Rezoning Transportation Analysis

Petition Number: 2023-091

From: Jake Carpenter, PE

Date	Description
9-28-23	First Review (NK)
10-26-23	Second Review (JP)

1/4" = 1'-0"

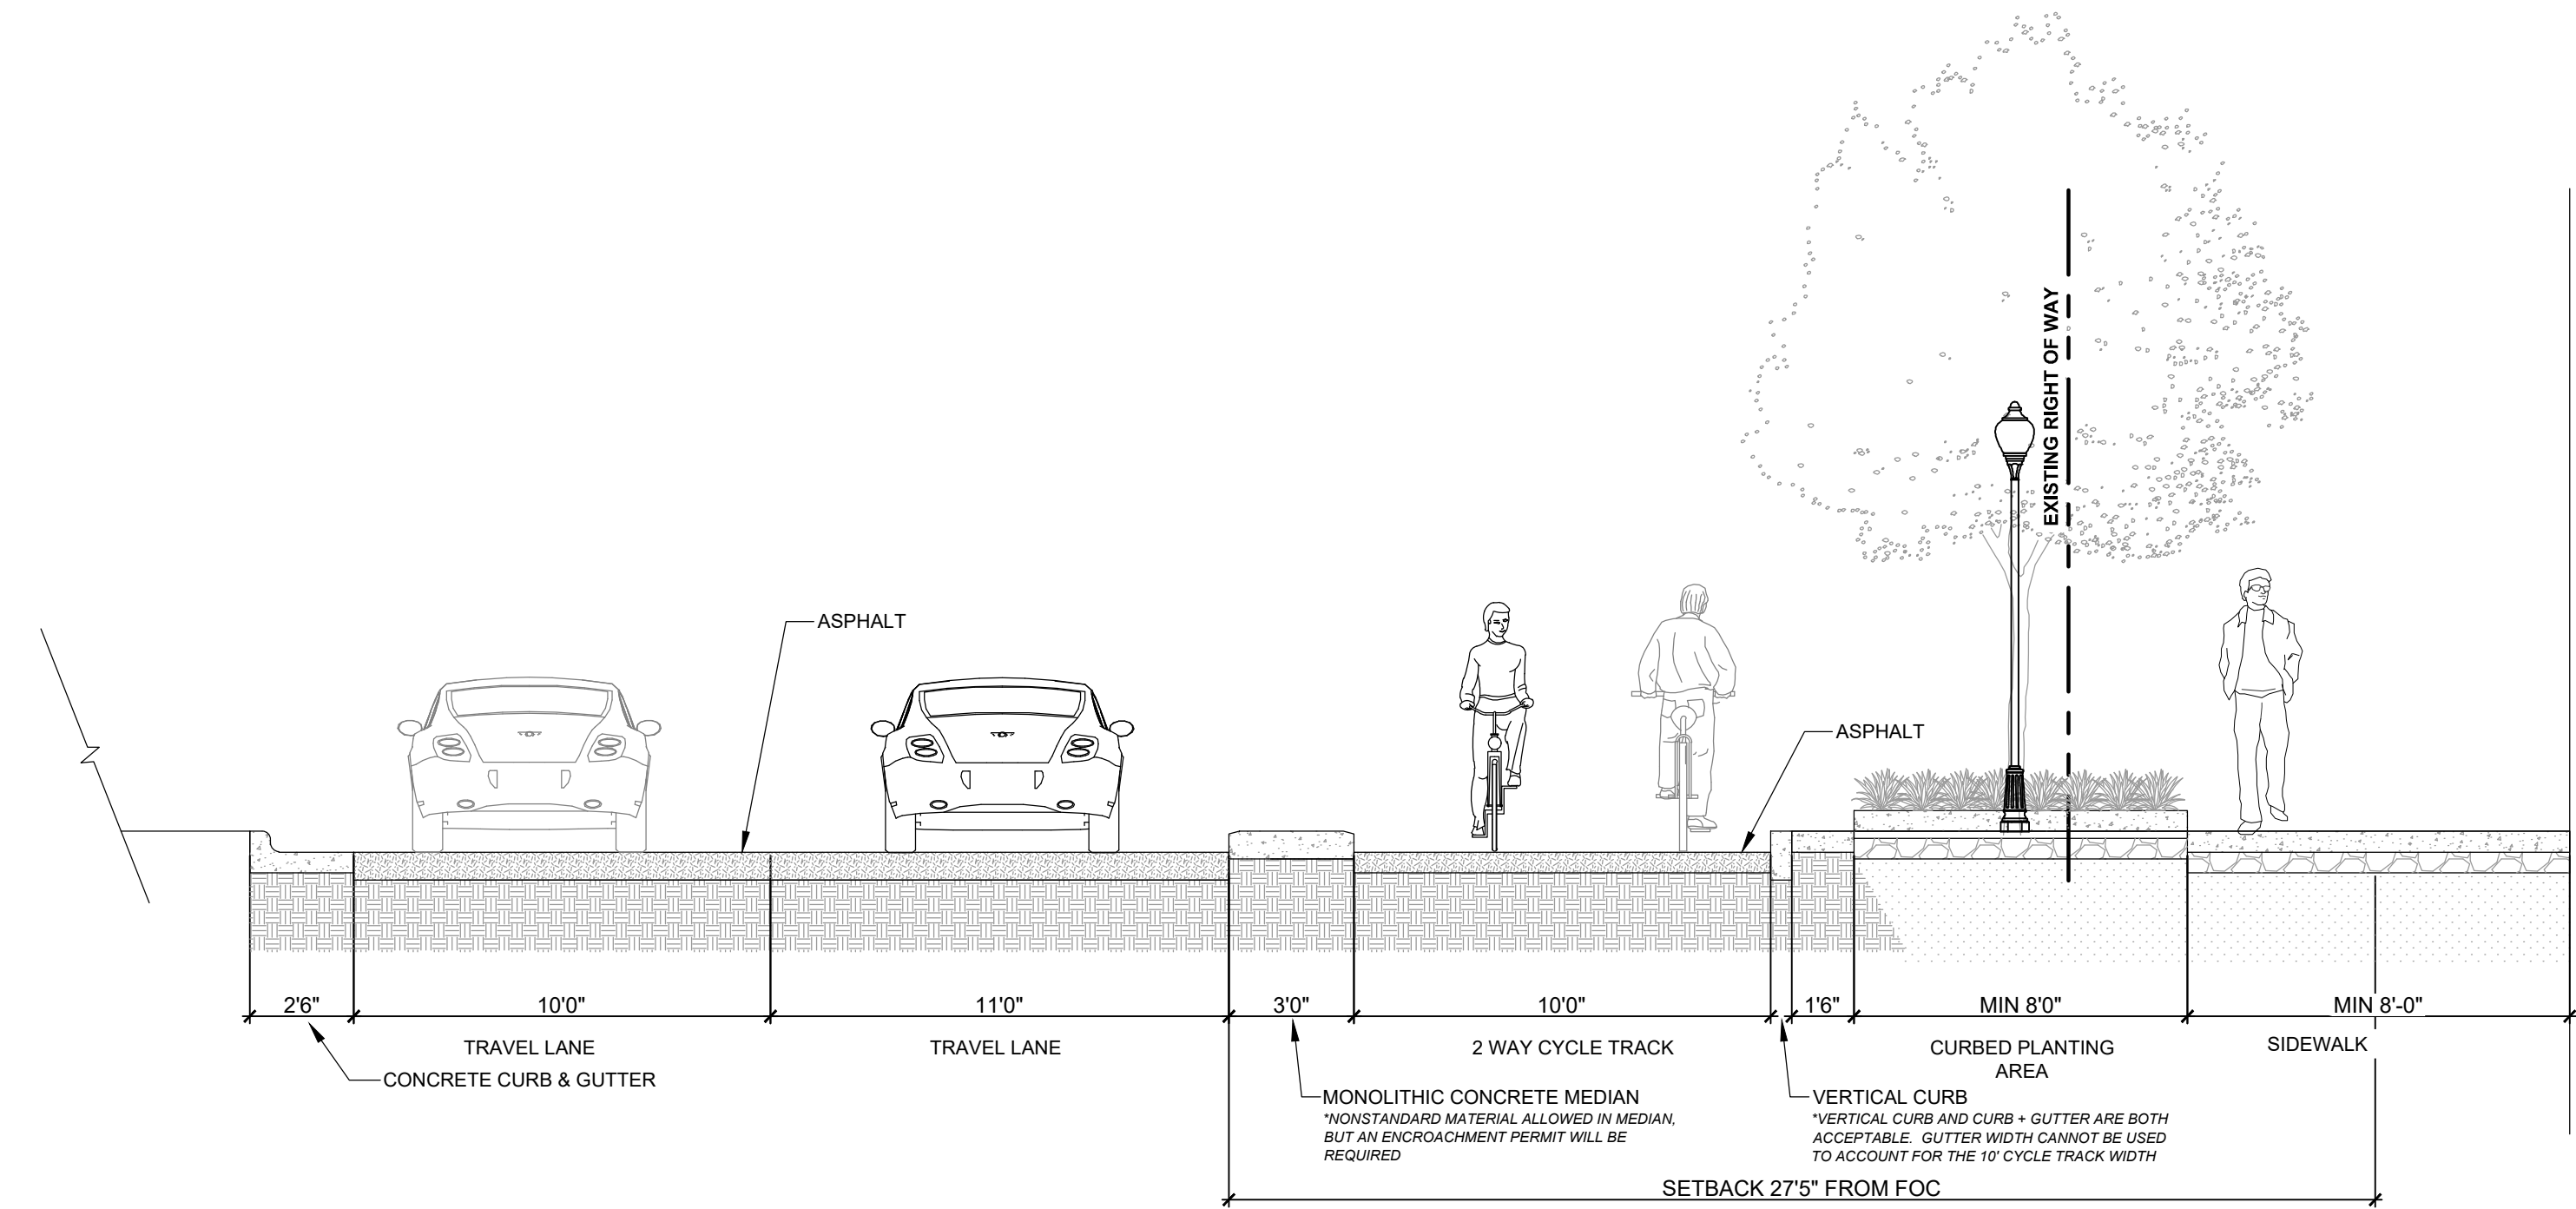
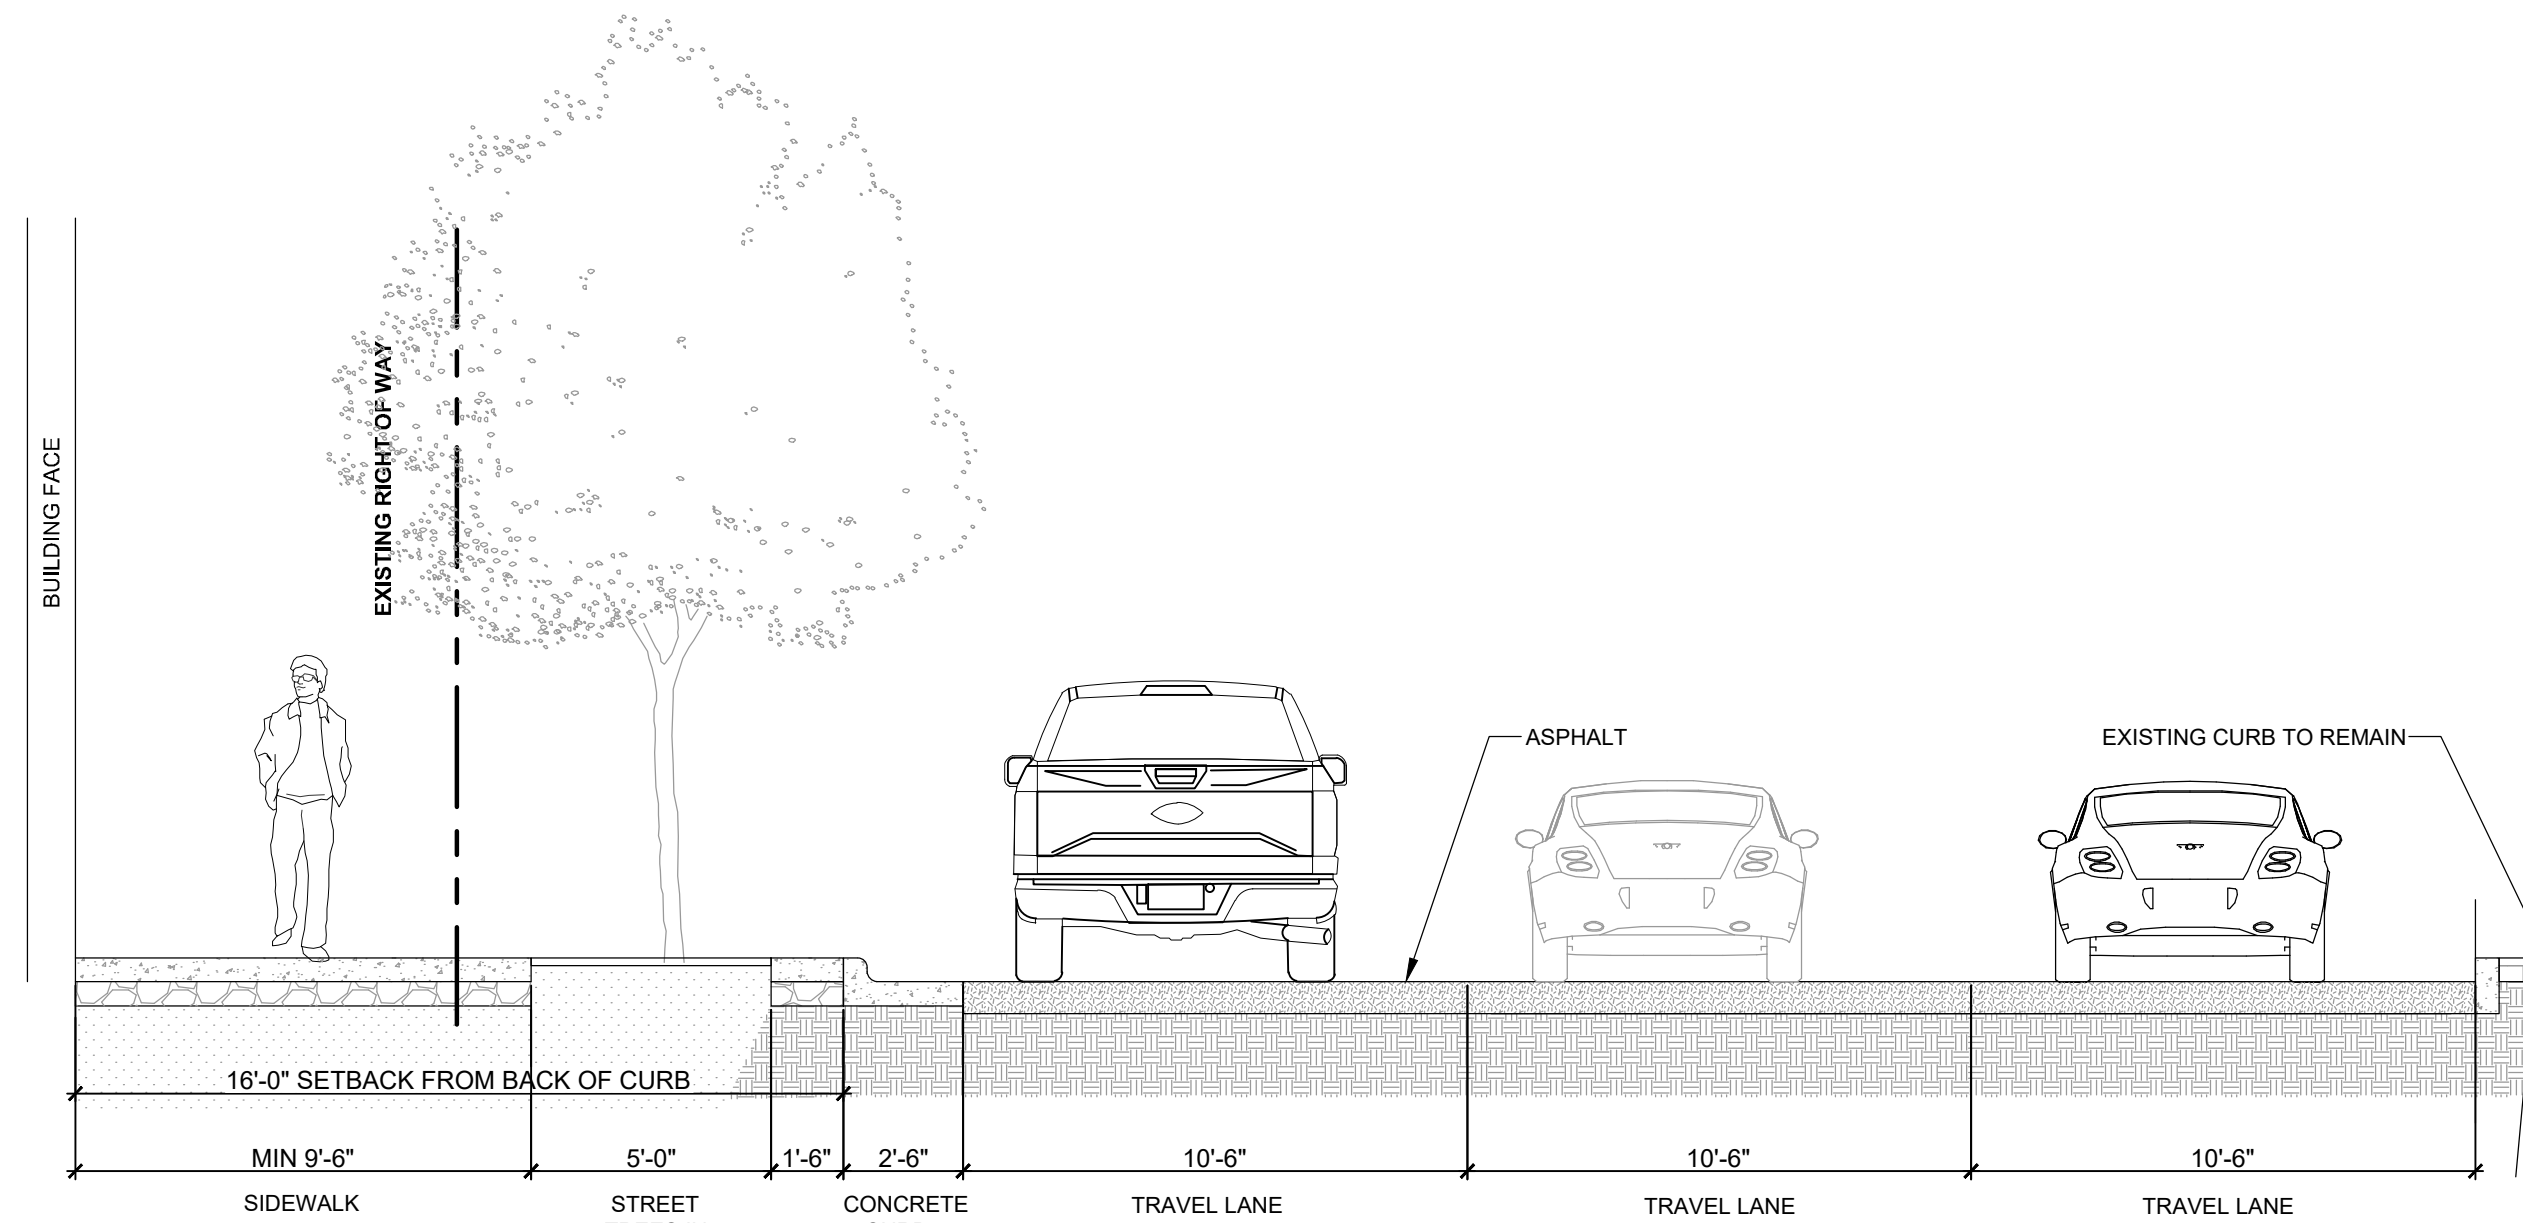
- ~~4. Revise site plan and conditional note(s) to commit to construct bicycle facilities by installing a 10' multi-use path along East 6th street, North College Street, and East 7th Street. in accordance with the council-adopted Charlotte Streets Map. Multi-use paths maintained by the City shall meet ADA/PROWAG requirements.~~

- ~~5. Revise site plan and conditional note(s) to commit to construct bicycle facilities by installing a 12' multi-use path along North Tryon Street in accordance with the council-adopted Charlotte Streets Map. Multi-use paths maintained by the City shall meet ADA/PROWAG requirements.~~
